TO: Dusty Pilkington, CDS  
FROM: Kelly Bacon, Engineer Technician I *KB*  
DATE: April 4, 2017  
SUBJECT: Gibb BL-17-00003

The Public Works Department has reviewed the Request for Boundary Line Adjustment and finds that it meets current Kittitas County road Standards.

SHEET 1 OF 2

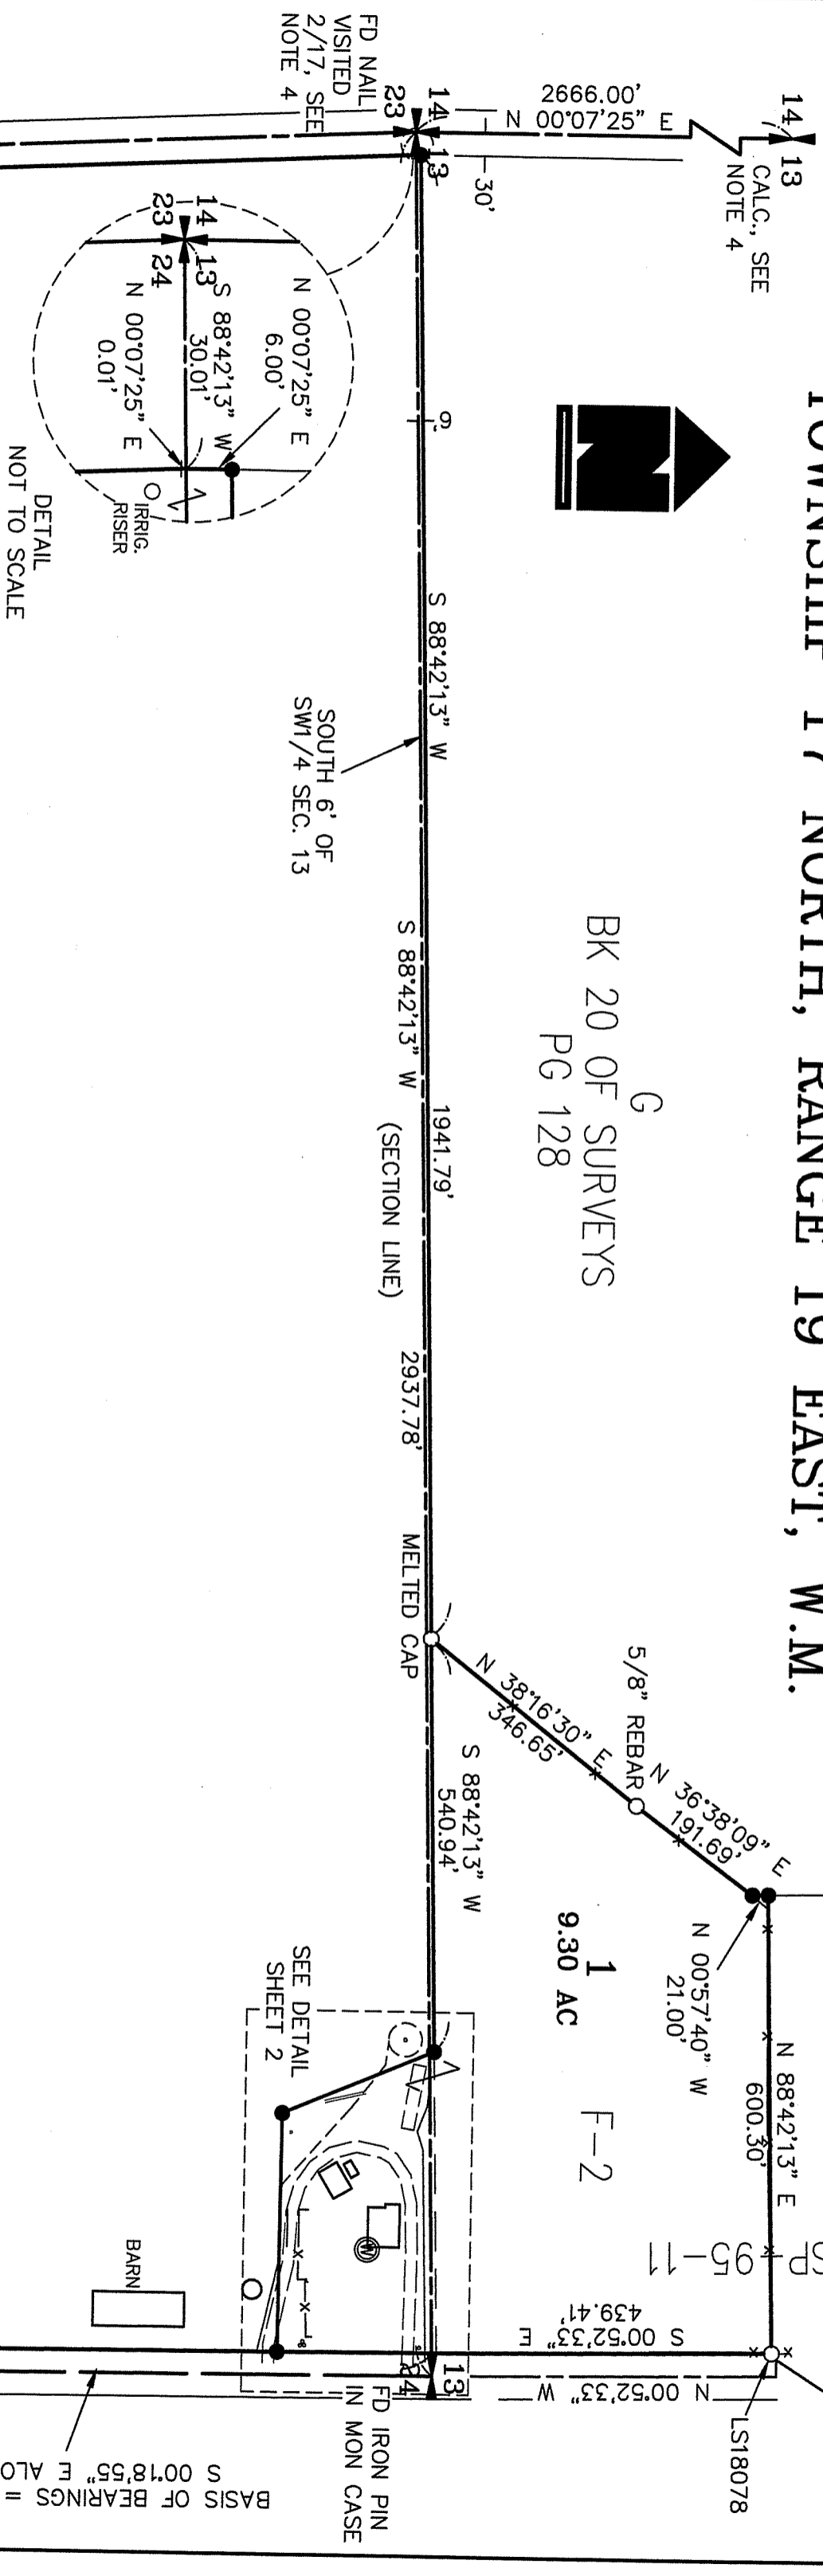
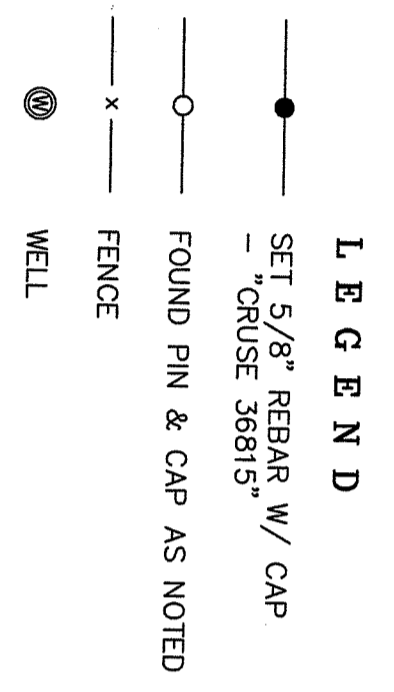
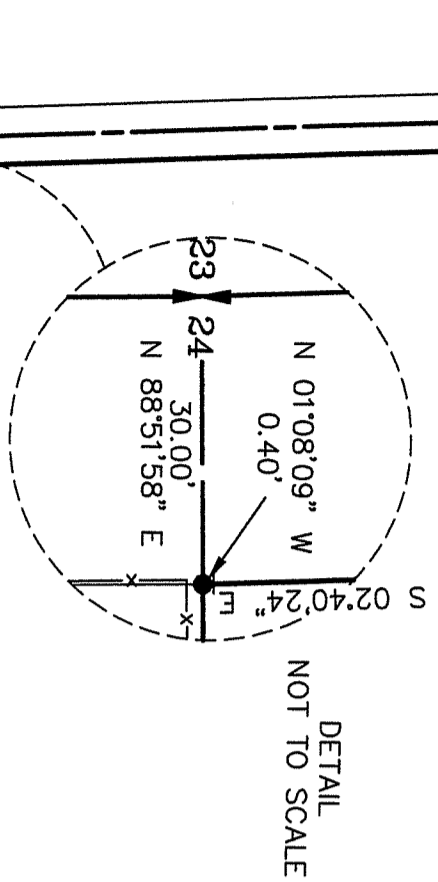
- a. Provide recorded access easement for the existing driveway across the northern portion of lot 2.
- b. An approved access permit shall be required from the Kittitas County Department of Public Works prior to creating any new driveway access or performing any work within the county road right of way.
- c. Maintenance of driveway approaches shall be the responsibility of the owner whose property they serve. The County will not maintain accesses.
- d. Any further subdivision or lots to be served by proposed access may result in further access requirements. See Kittitas County Road Standards.
- e. Evidence of existing access and/or evidence of access to be created should be confirmed prior to sale of property.
- f. Access is not guaranteed to any existing or created parcel on this application.
